# M25 junction 10/A3 Wisley interchange

## TR010030

### 9.5 DCO Application Errata Schedule

#### 9.5 DCO APPLICATION ERRATA SCHEDULE

SHEET 14 OF 31

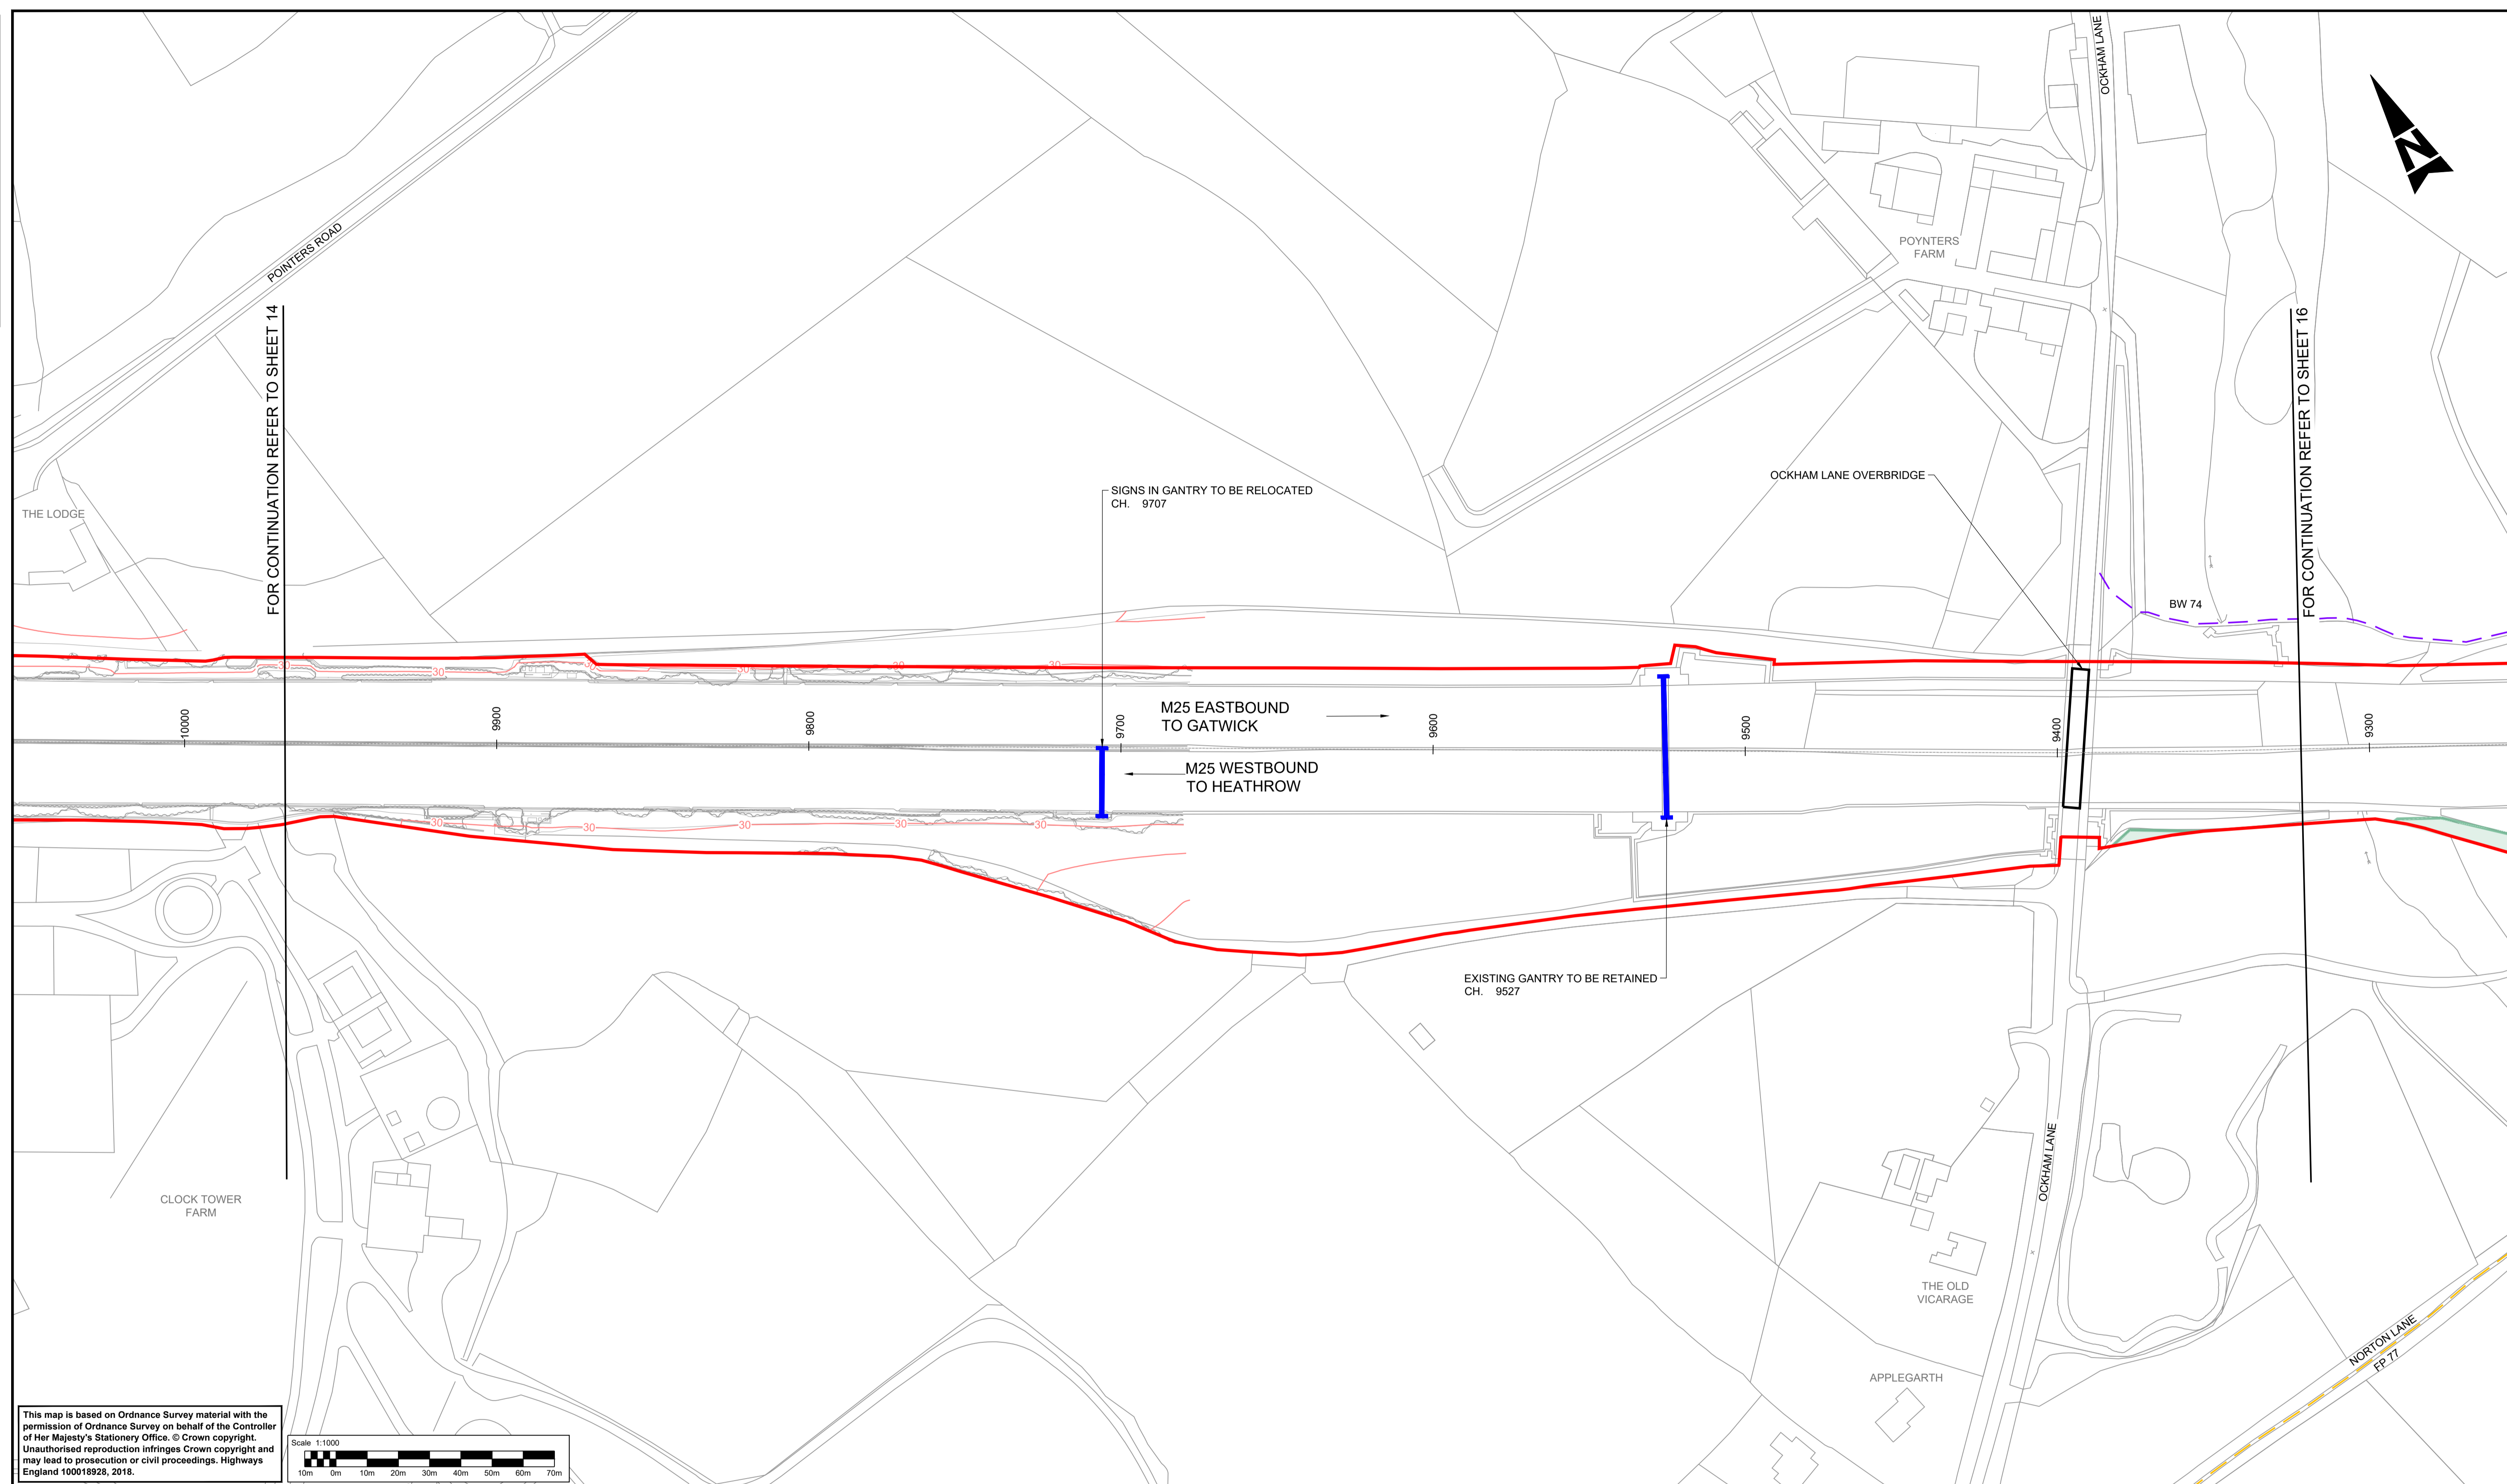
APP-013	2.8 Scheme Layout Plans (Sheets 11-31 of 31)	Sheet 12 of 31	The label reading "Buxton Wood" is to be removed	Remove the label.
APP-013	2.8 Scheme Layout Plans (Sheets 11-31 of 31)	Sheet 13 of 31	The label reading "Ramp to be provide to earthworks to direct bridleway to new Wisley interchange NMU bridge" is incorrect.	Change text "Earthworks ramp to be provided to connect new bridleway to new Sandpit Hill overbridge."
APP-013	2.8 Scheme Layout Plans (Sheets 11-31 of 31)	Sheet 13 of 31	The replacement land hatch for Breach Hill Wood replacement does not cover Pointers Road within the DCO boundary and the proposed management of existing woodland does not cover the	Extend the hatched area.

Drawing Title: <b>SCHEME LAYOUT PLANS REGULATION 5(2)(o)</b>	
SHEET 28 OF 31	
Client: <b>TR010030/APP/2.8</b>	Rev: <b>3</b>
HE PIN: HE551522	Scale: 1:1000 Original Size: A1

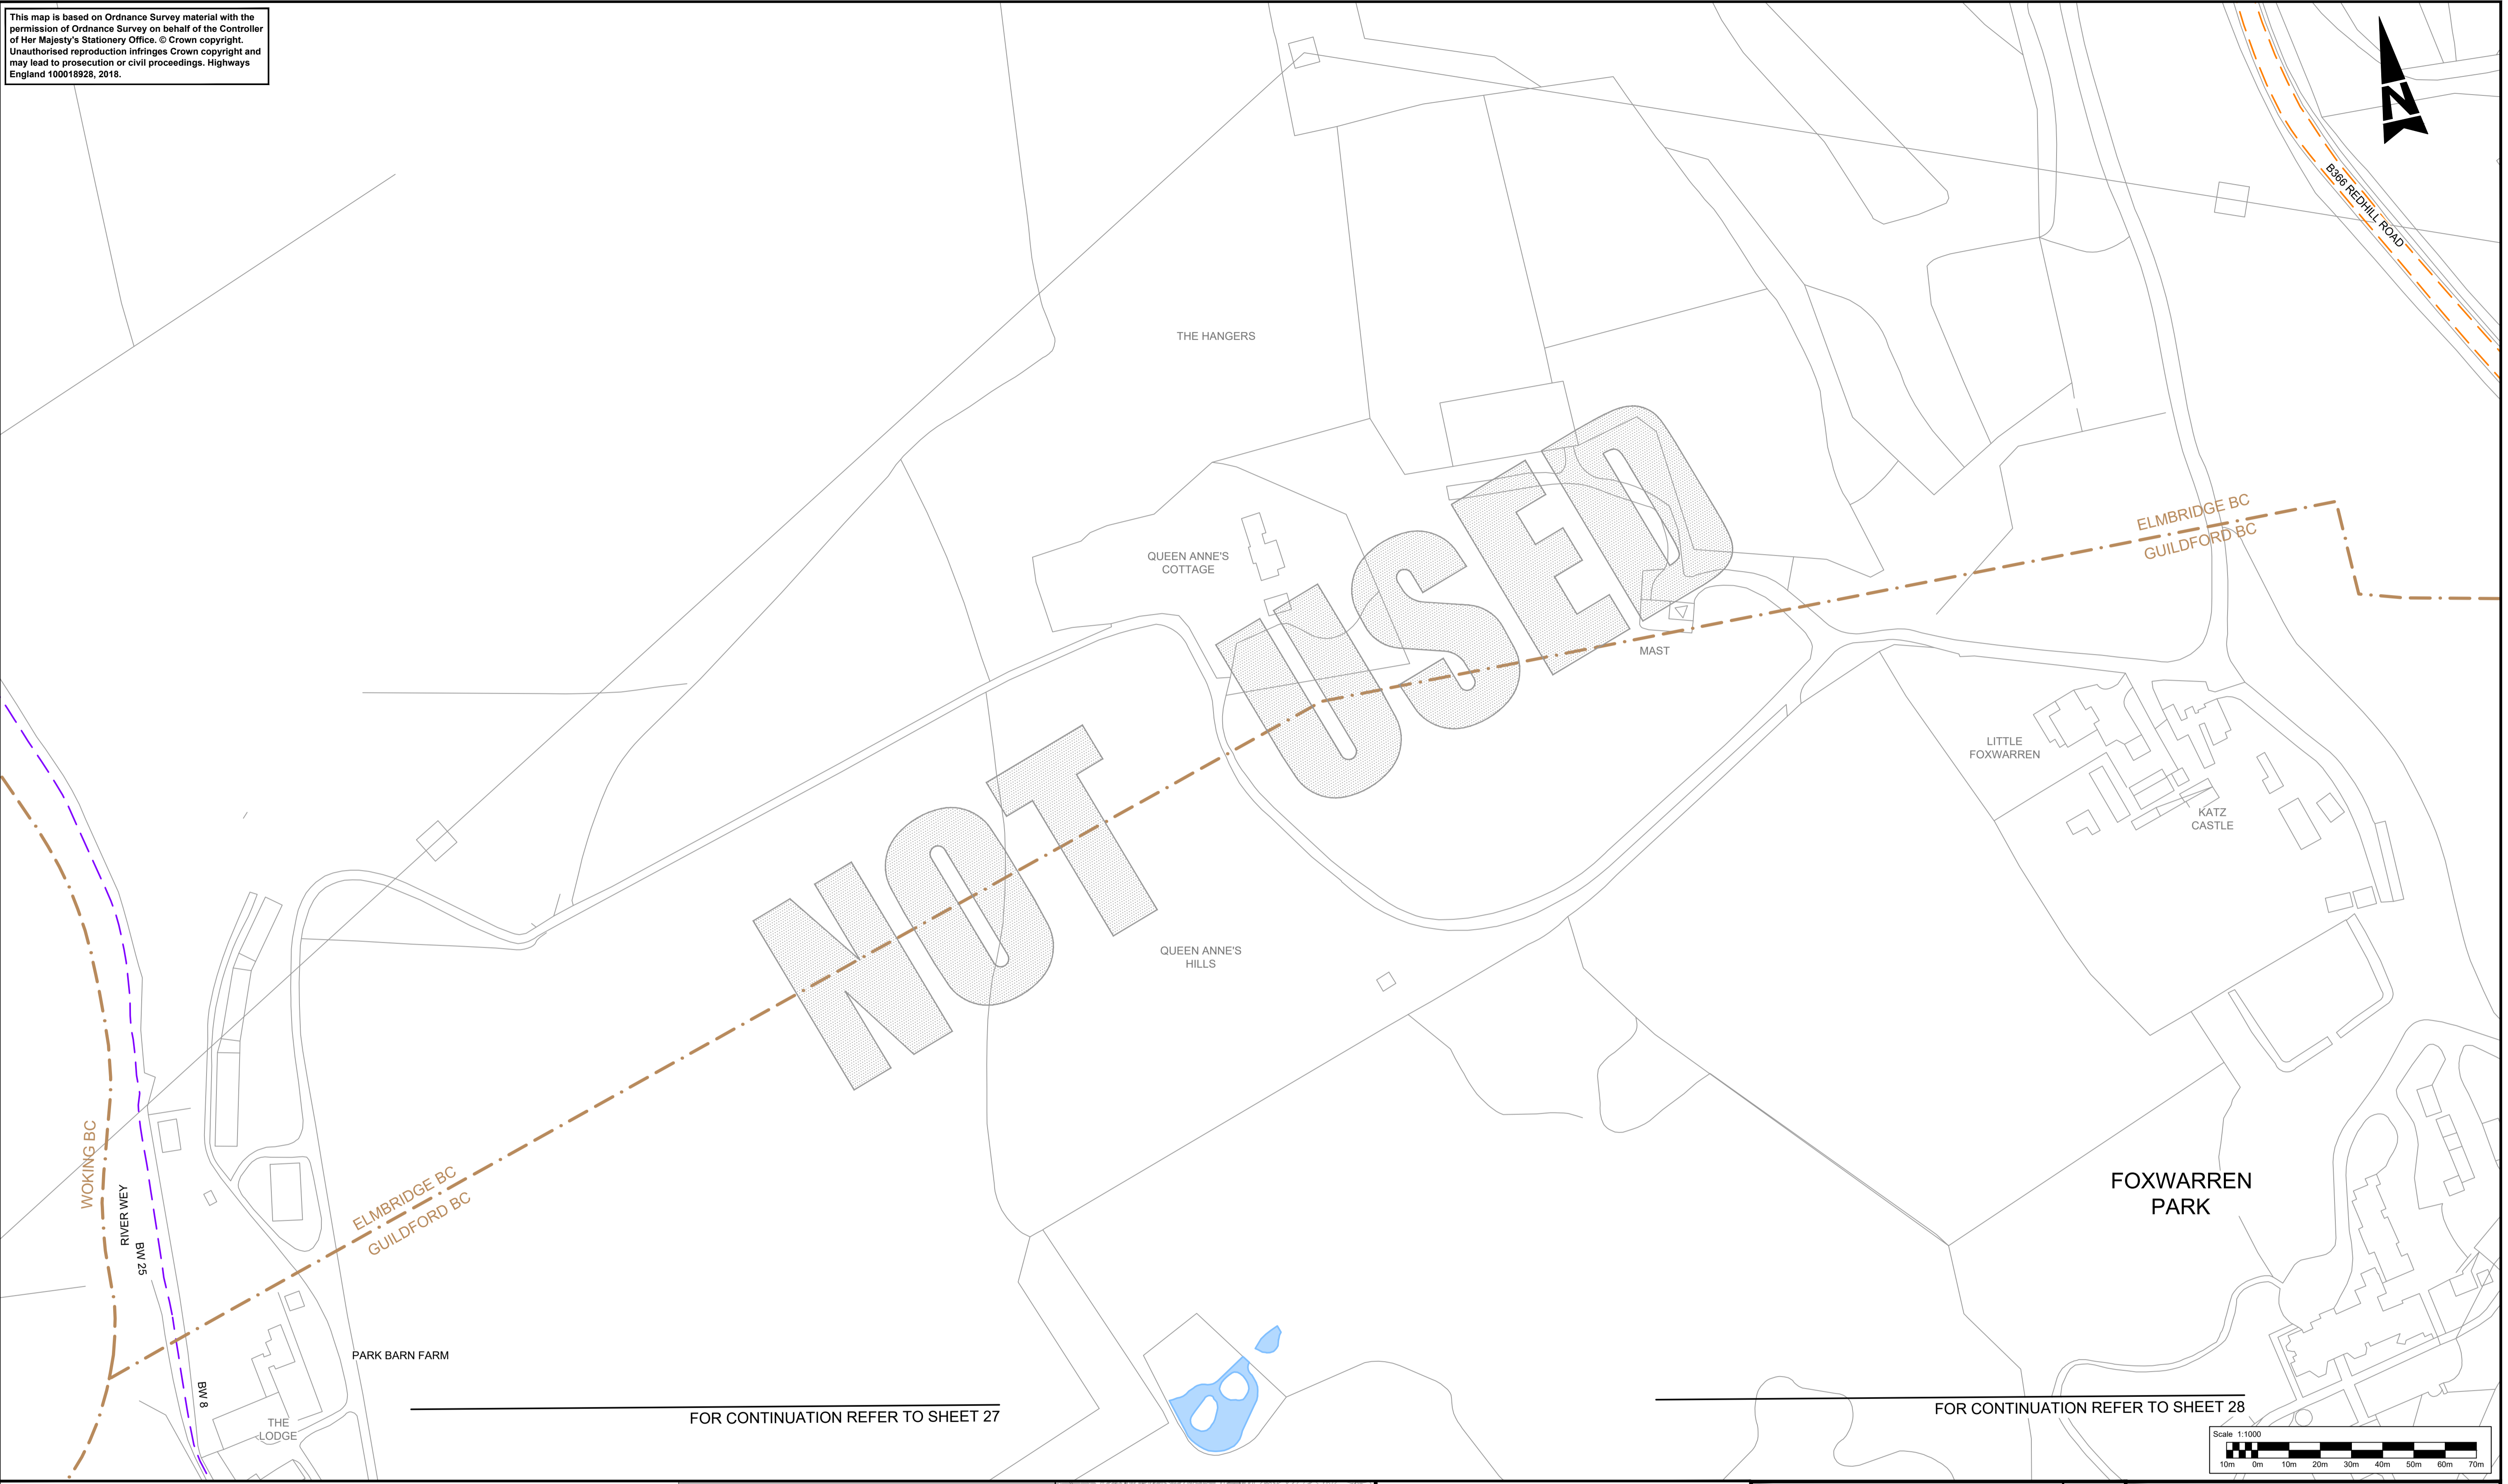
APP-013	2.8 Scheme Layout Plans (Sheets 11-31 of 31)	Sheet 28 of 31	Incorrectly drawn boundary for the tree preservation order to be protected.	Boundary redrawn up to the DCO boundary.
APP-023	4.1 Statement of Reasons Appendix C: Common land sheets 5 and open space report	Appendix C, Table C.1, C.3, C.4, C.5, C.6 and C.7	“Error! Not a valid link” displayed instead of the Table.	Insert Table into the document. Provided on 24 July 2019 as part of response to S51.
APP-023	4.1 Statement of reasons Appendix C	Table C.7	Table C.7 does not accommodate changes to the Special land dimensions	Additional Land Parcels need to be inserted into C.7.
APP-039	5.3 Habitats Regulations Assessment Figures	Whole document	Figures have not appeared online when submitted at DCO Application. We were asked to update at S51. Since then PINS have further asked us to change some of the ordering of the plans and Contents Lists.	Document Rev 2.0 provided to PINS on 5 November 2019.
